MEMORANDUM

Client: St. Catherine's School, Waverley
Project: Staged Campus Master Plan + Stage 1 (RPAC)
Site Address: 26 Albion Street, Waverley, New South Wales
Attention: **Ms. Megan Fu**
Contact Officer
NSW Department of Planning and Environment

Subject: **Response to Submissions (14 Day Notification)**

Figure 18 – Proposed vehicular and pedestrian entry points (source: Mayoh Architects, A.MP.007)

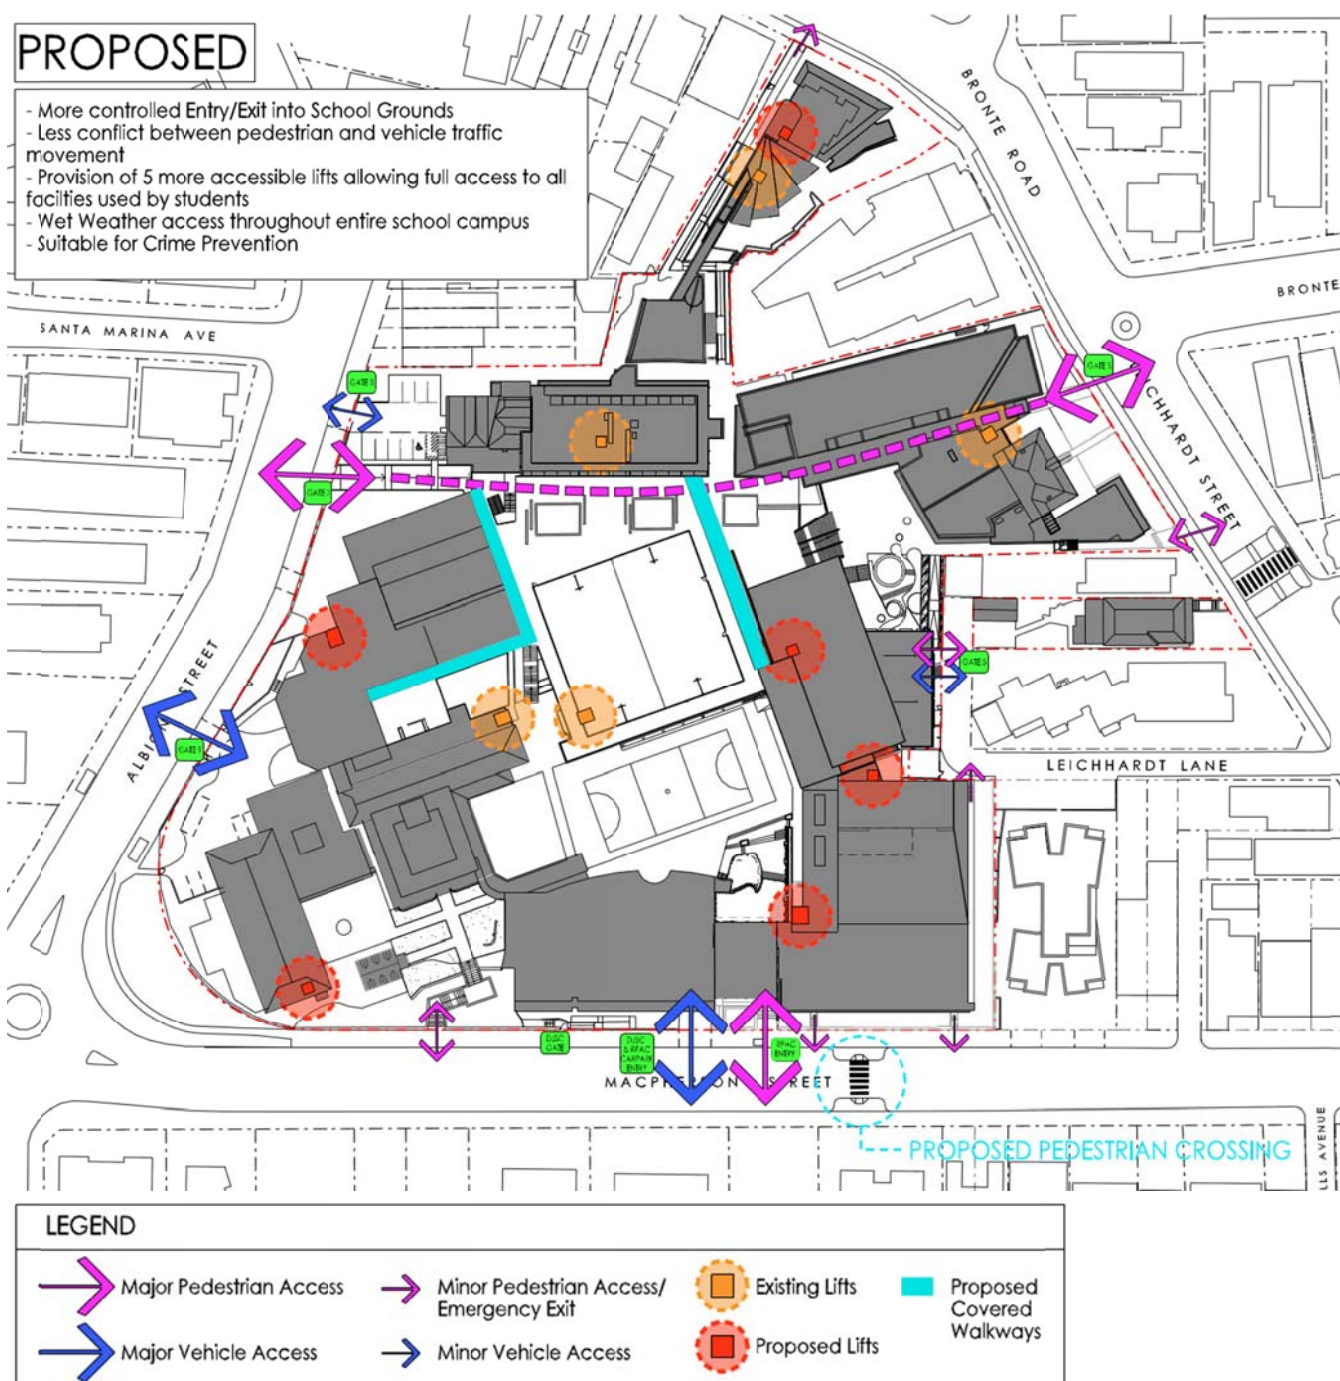
Description	Authority	Response
1 Assess impact of relocated bus stop on parking availability on southern side of Macpherson St. The assessment should consider the requirements of relocated pedestrian crossing and associated no parking/stopping clearance requirements.	NSW DP&E	Refer revised Transport Report prepared by Arup.
2 Clarify situation regarding proposed bus stop relocation on Leichhardt St and if required, revised PD Mayoh Plan A.MP.007.	NSW DP&E	Refer Section 2.1
3 Clarify external use of Aquatic Centre to facilitate Water Polo activities (e.g. weekends, men's comp., after school weekdays etc.).	NSW DP&E	Refer Section 2.2
4 Confirm how many car spaces are located along the school frontages outside of restricted parking time zones.	NSW DP&E	Refer revised Transport Report prepared by Arup.
5 Confirm whether there is 19 or 20 drop-off spaces along Macpherson Street (extra 2 or 3 spaces) and confirm that the drop-off/pick-up spaces factor in any No-Stopping requirements of the relocated pedestrian crossing. Plan A.MP.007 shows the spaces being located right up to the pedestrian crossing.	NSW DP&E	Refer revised Transport Report prepared by Arup.

At the time of commencement of the preparation of the Development Application, the subject Bus Stop located on the west side of Leichhardt St was located south of Leichhardt Ln and north of the Leichhardt St/Macpherson St roundabout.

On 27 March, 2014, the Waverley Traffic Committee (WTC) resolved (independent of the Development Application) to relocate this Bus Stop to the north side of Leichhardt Ln and south side of the Leichhardt St Pedestrian Crossing (refer WTC meeting minutes from meeting conducted 27 March, 2014) for a trial period of 1 school term.

The Leichhardt St Bus Stop is currently located approximately 50m north of the Pedestrian Crossing and south of the Bronte Road roundabout. It appears that the Bus Stop has remained in this location since the trial which commenced during the second half of 2014.

As a result, the drop-off/pick-up zone for the St. Catherine's School Junior School students now occurs on the south side of the Pedestrian Crossing on the west side of Leichhardt St.

The School has adjusted its pick-up/drop-off operations to suit the new bus stop location. Concerns regarding the potential trip hazard caused by the green strip (particularly in the wet) were discussed with Waverley Council. Resolution of these concerns is now agreed and the School will fund Council concreting the green strip.

Refer to Attachment 1 for a revised plan A.MP.007 reflecting the current bus stop and pick-up/drop-off locations.
